Subject: FW: AB/63/20/DOC 74-76 Canada Road, Arundel, West Sussex BN18 9HY - Planning Conditions 4 & 8

Subject: RE: AB/63/20/DOC 74-76 Canada Road, Arundel, West Sussex BN18 9HY - Planning Conditions 4 & 8

Condition 4 – Construction Plant and Materials

Condition 8 - Access

- Indicates Site Cabin - Oasis Unit Location
- Indicates Proposed Materials offloading Area to Storage Area/s.
- Indicates Proposed Materials Storage Area
- Indicates Proposed Contractor Parking Provision (on-street)

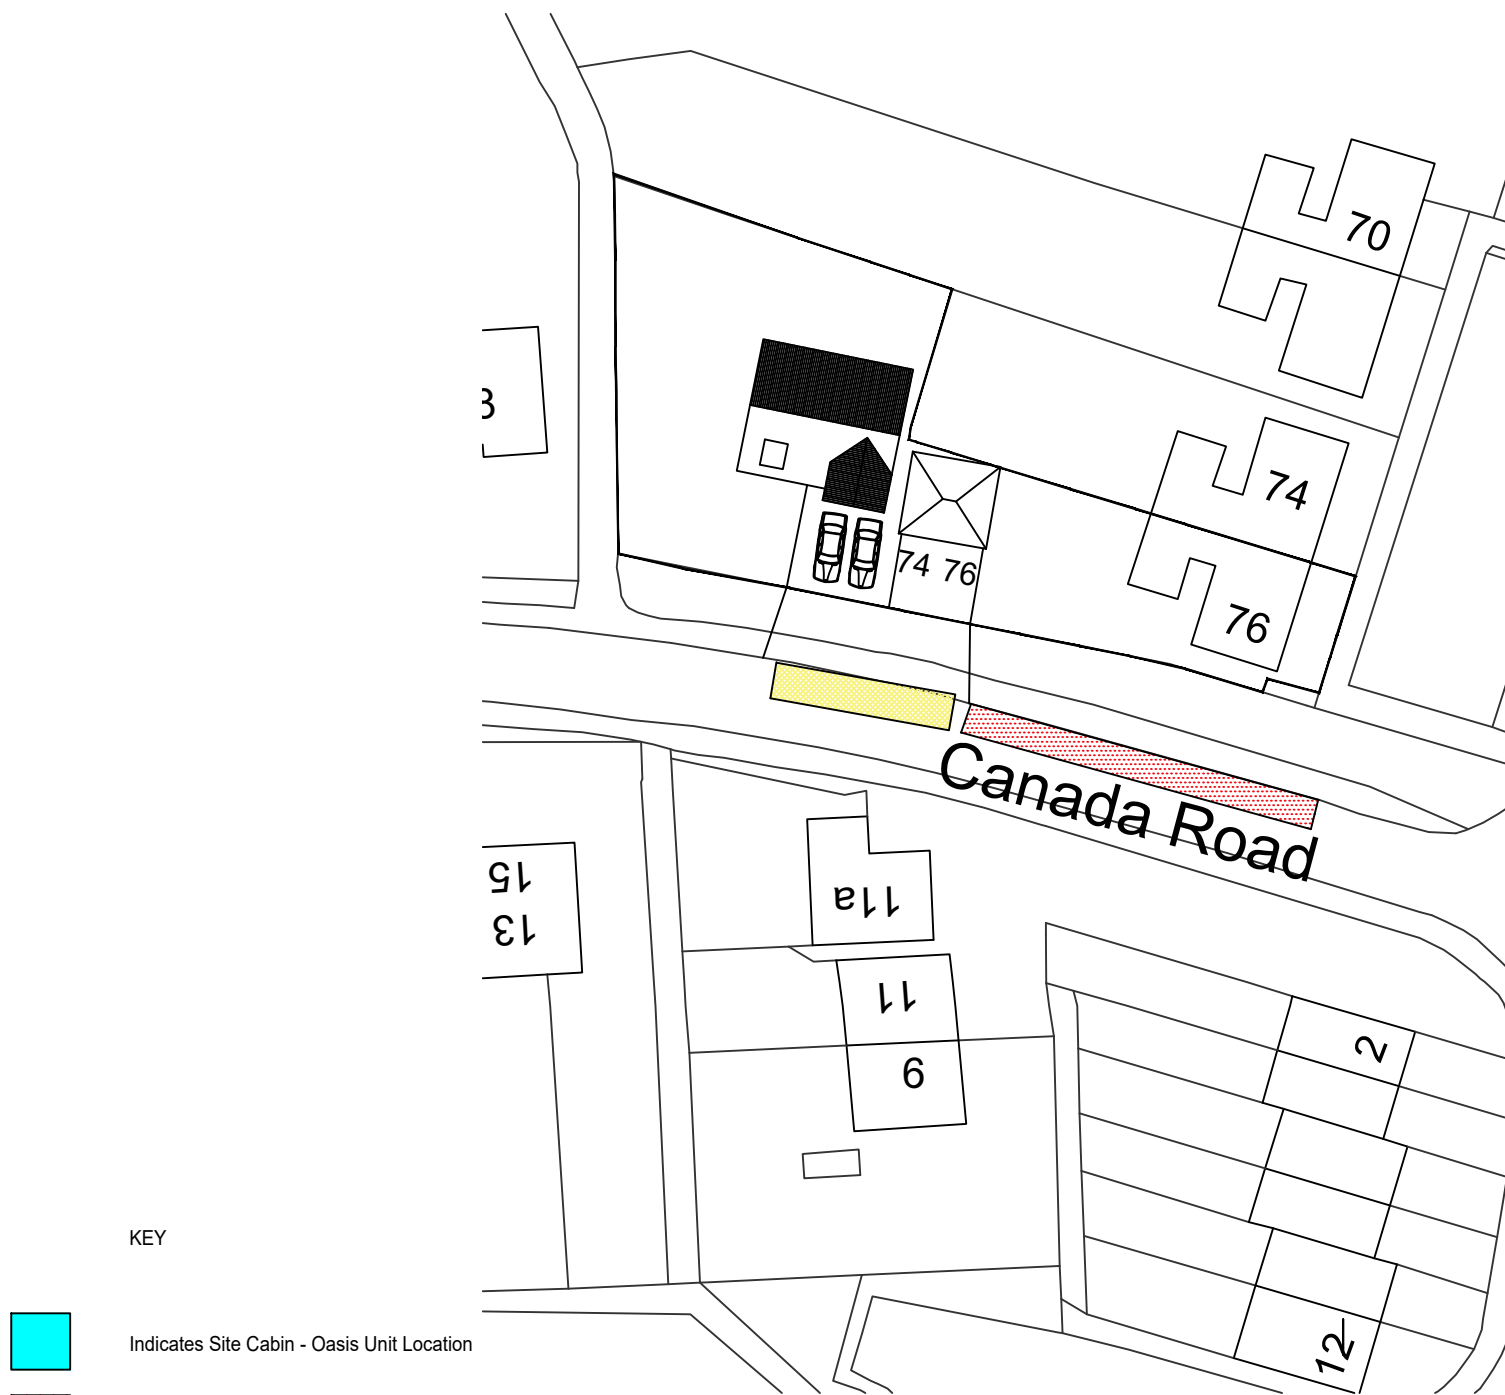
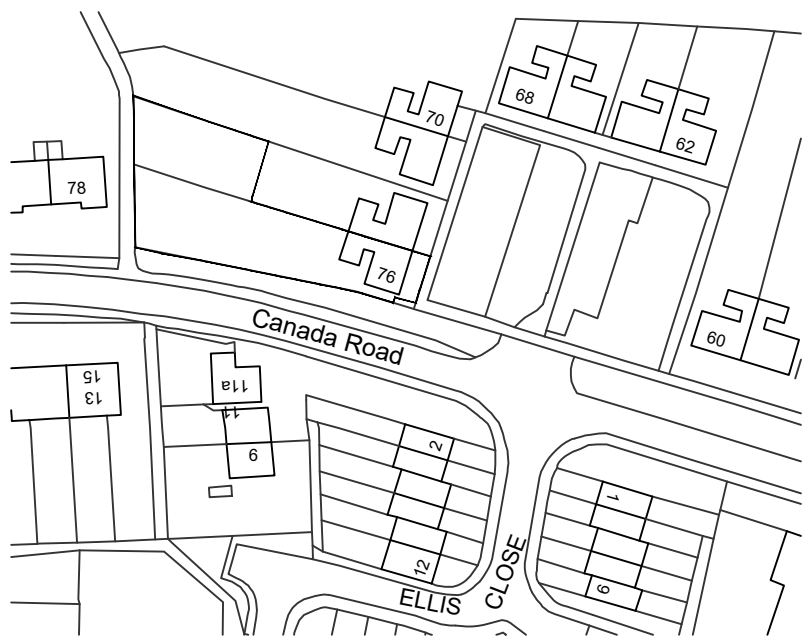
As per, and adding to Stephens comments 30th July WSCC. Parking by contractors can naturally take place on street while taking into consideration any existing traffic regulation orders. However it is not advised that a specific area for this is marked on discharge of condition plan. This is because the roads status as public highway is secured by statute and thus should be free for use by all. It would also restrict contractors to only parking in those specific locations when they may not be free.

This could be mitigated by way of a temporary traffic regulation order, but the applicant does not seem to be proposing this.

It would be better if a statement was made similar to “Due to the constraints of the site contractors will be required to park on street in a safe and considerate location. Any such parking must take into consideration any existing traffic regulation orders.

Similarly with materials storage, typically we try and avoid this if possible but it can be permitted with the appropriate licence agreement from WSCC Highways. Please can the applicant confirm if they do wish to store materials on the highway and I will enquire with the area office if ‘in principle’ such a licence would be forthcoming in such a location.

SWEPT PATH ANALYSIS WITH 6.4m CROSSOVER
(1:100)

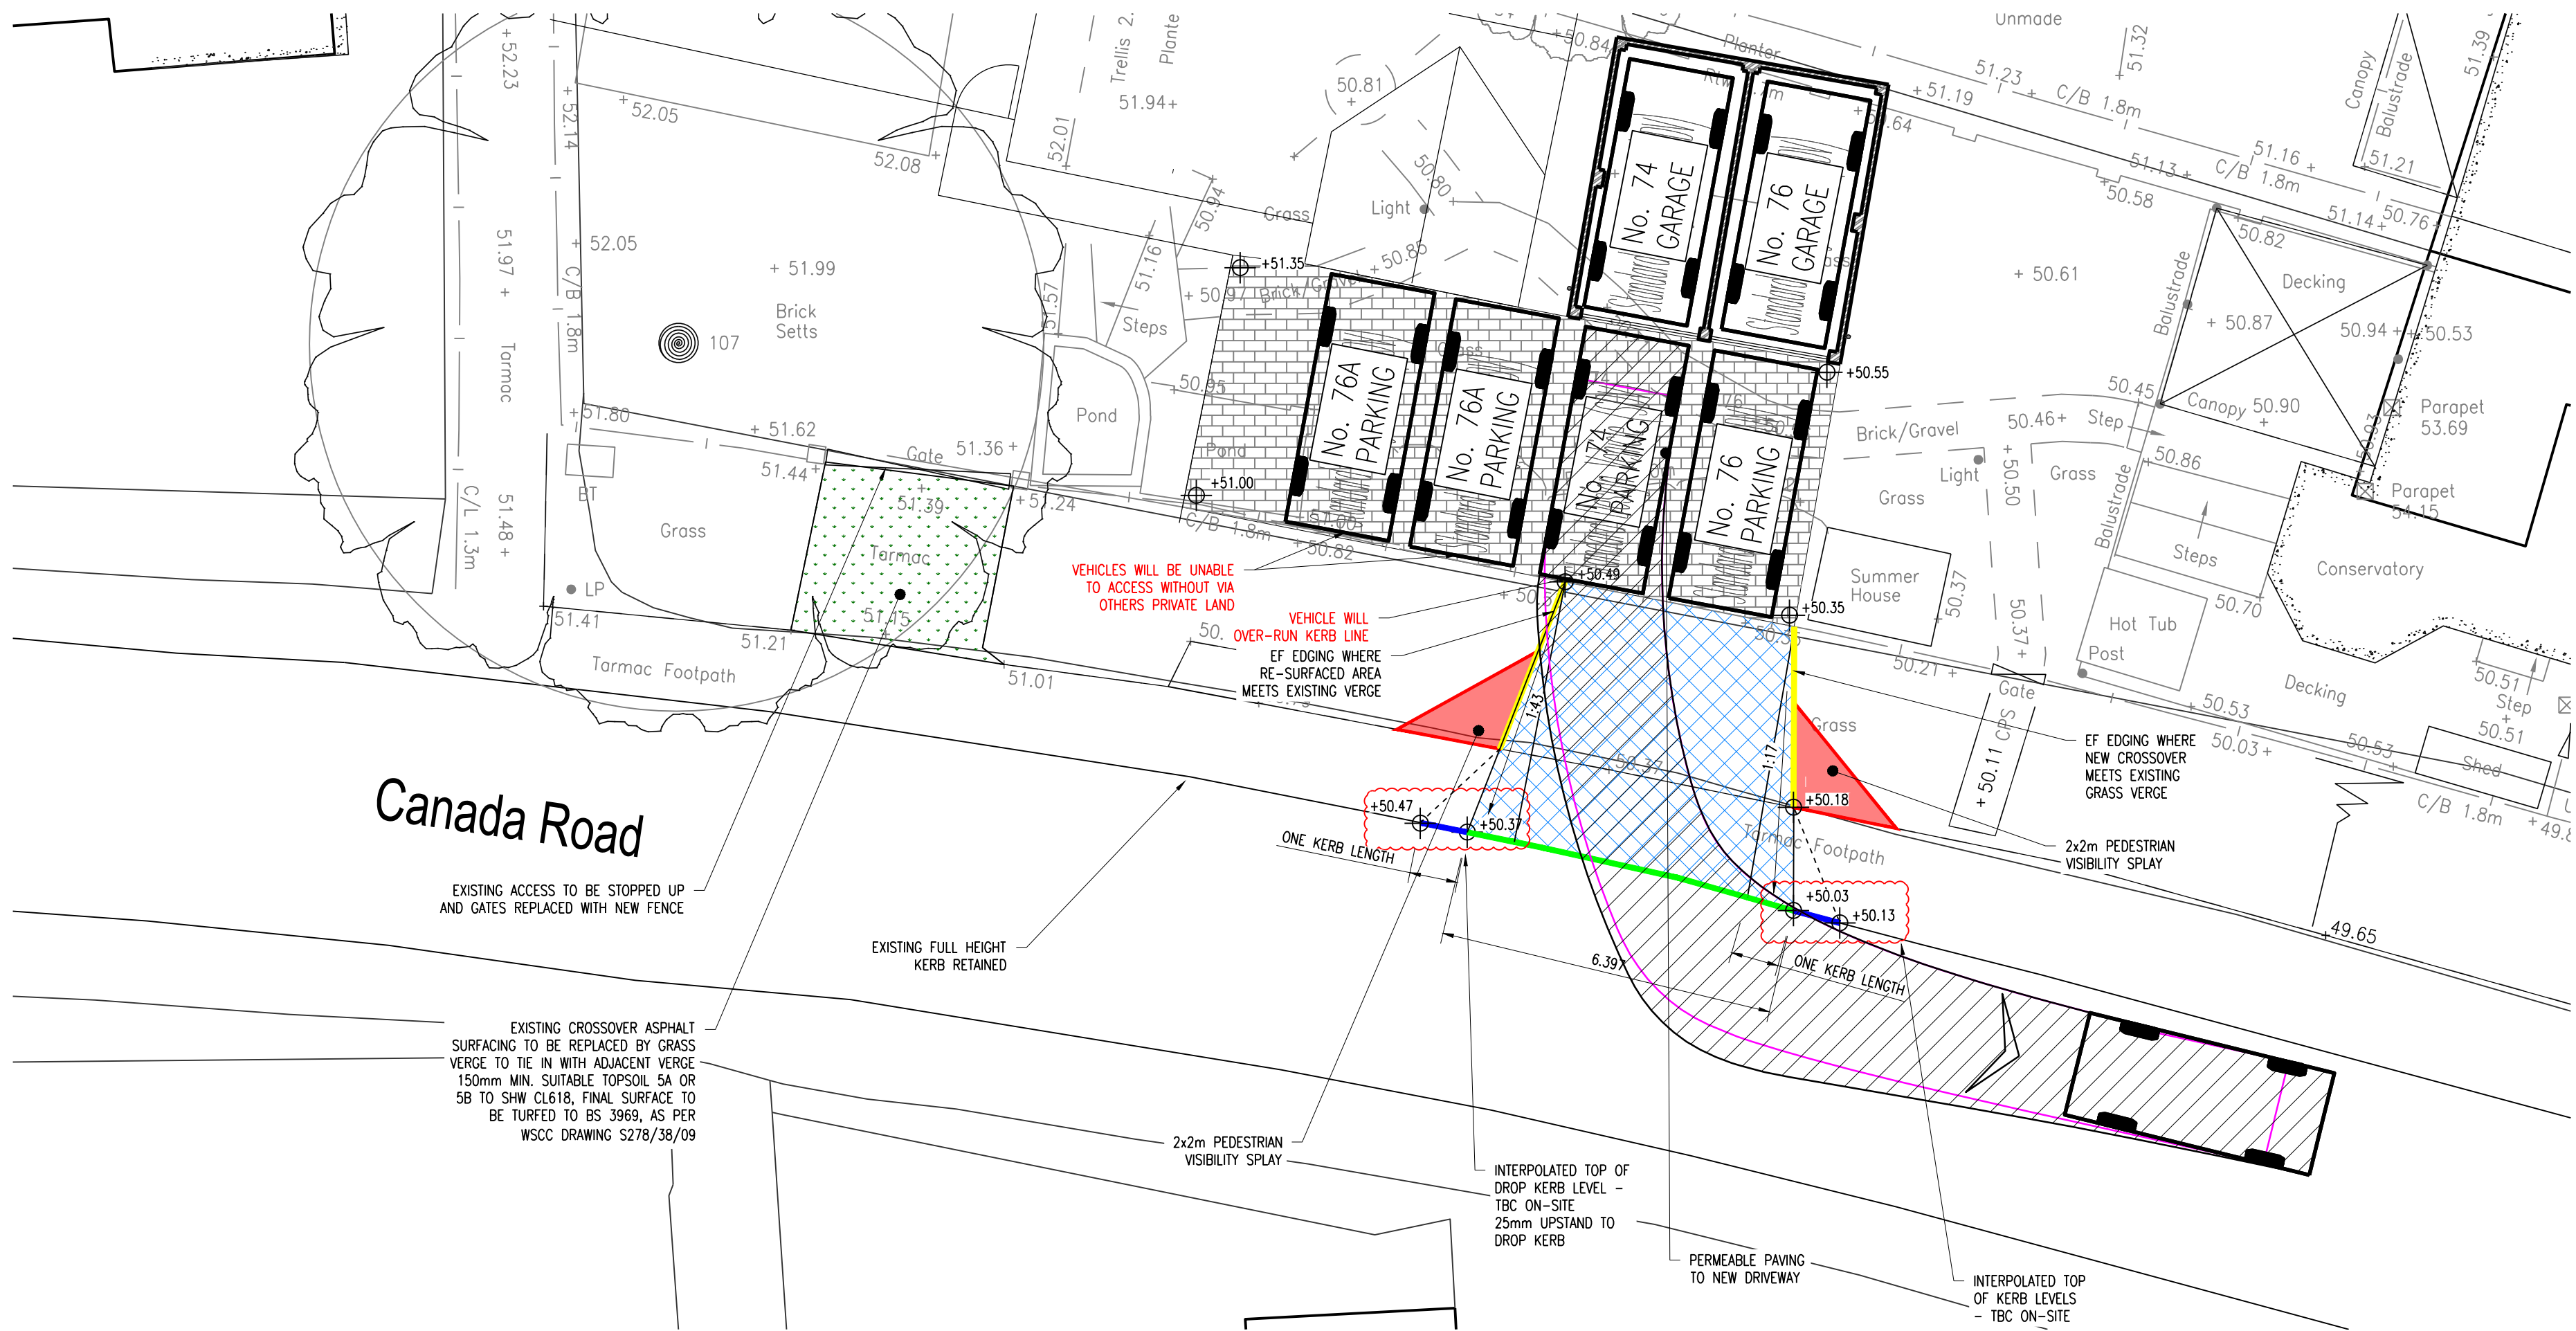
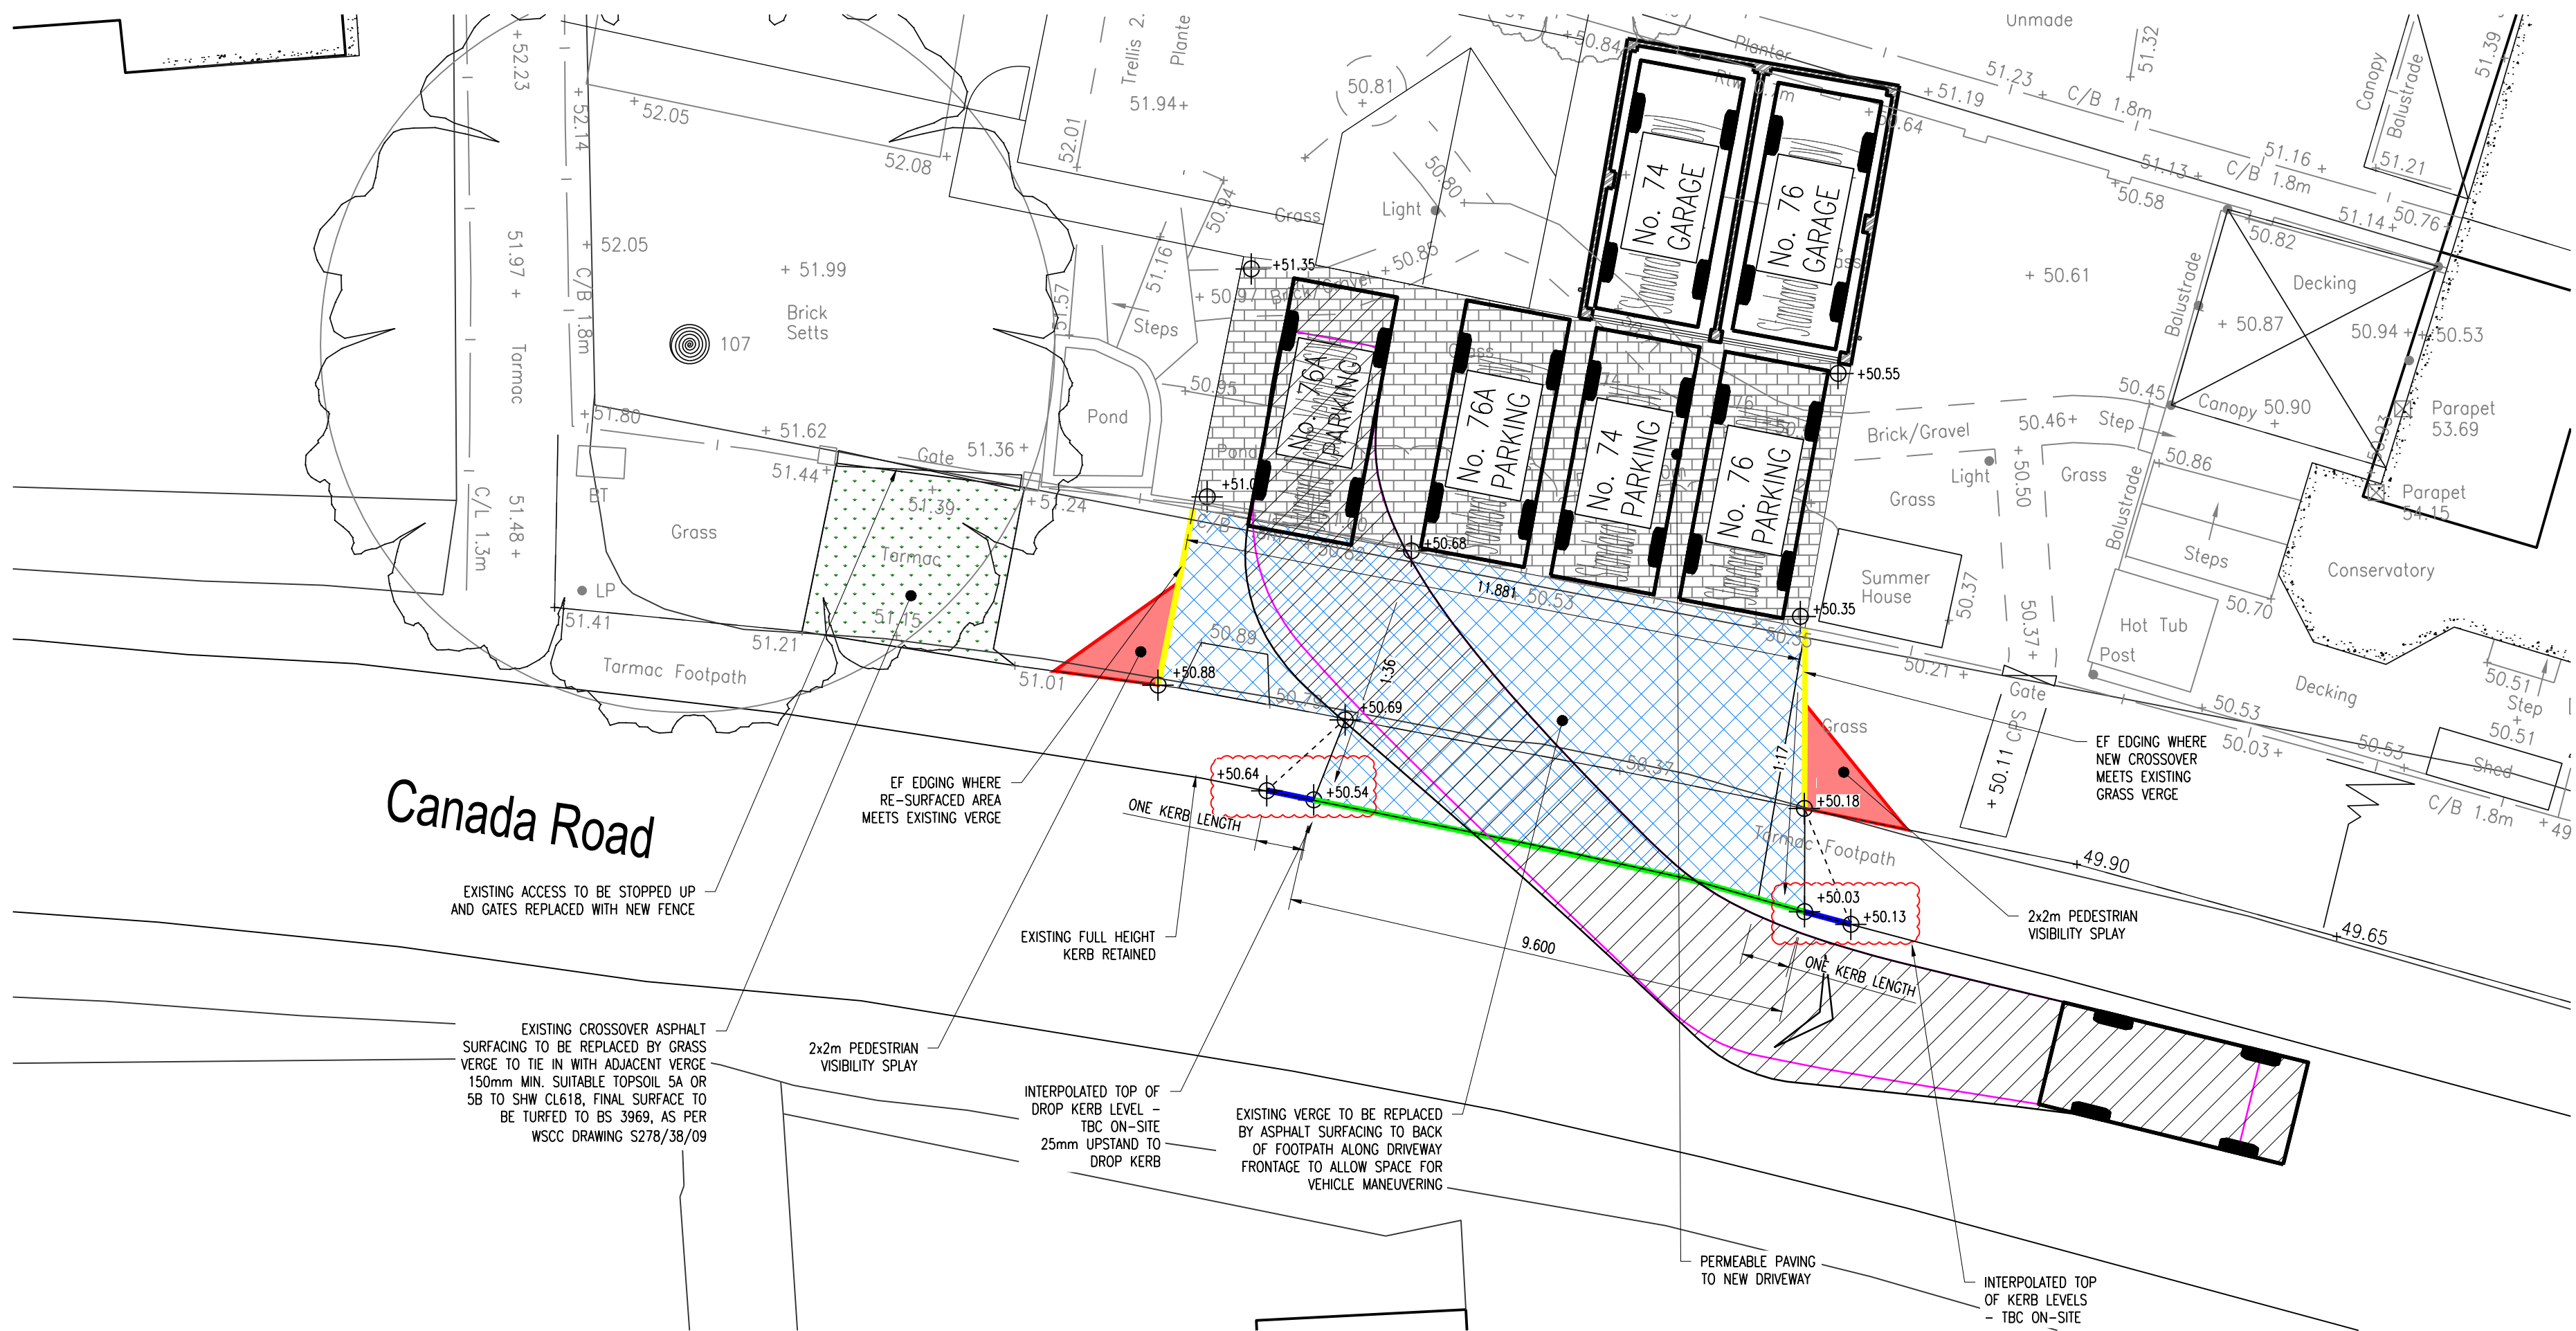
Am I right in thinking they have not submitted any plans that show a reduced width crossover at 6.4m wide? I can’t see such plans on the Arun Planning Portal or on the email string. The latest seems to be Plan 101A as attached to one of Glenns emails.

Glenn seems to be asking if a crossover width of 9.6 metres would be acceptable. I can see the logic behind this as it would allow for convenient access to the garage spaces and hardstanding for 74 and 76 Canada Road and allow for access to the proposed parking spaces for the new dwelling. To my mind a 6.4m wide crossover may limit accessibility for some of the spaces, though its difficult to say this with any certainty as that has not been demonstrated to date.

Our area office are resistant in granting licence application grater than 6.4 metres in width due to the loss of on street car parking provision. I think the only way forward is to present to the area office a plan that shows how a 6.4m wide crossover is not workable. I.e. showing a 6.4 crossover where it is then clear that vehicles accessing the new parking spaces will be required to bump the kerb in order to access the approved parking spaces. A similar plan showing a 9.6 metre wide crossover or greater can then be provided to show the minimum width required to provide a workable solution. This will then be materially different to what we have presented to the area office with to date to provide us a view on.
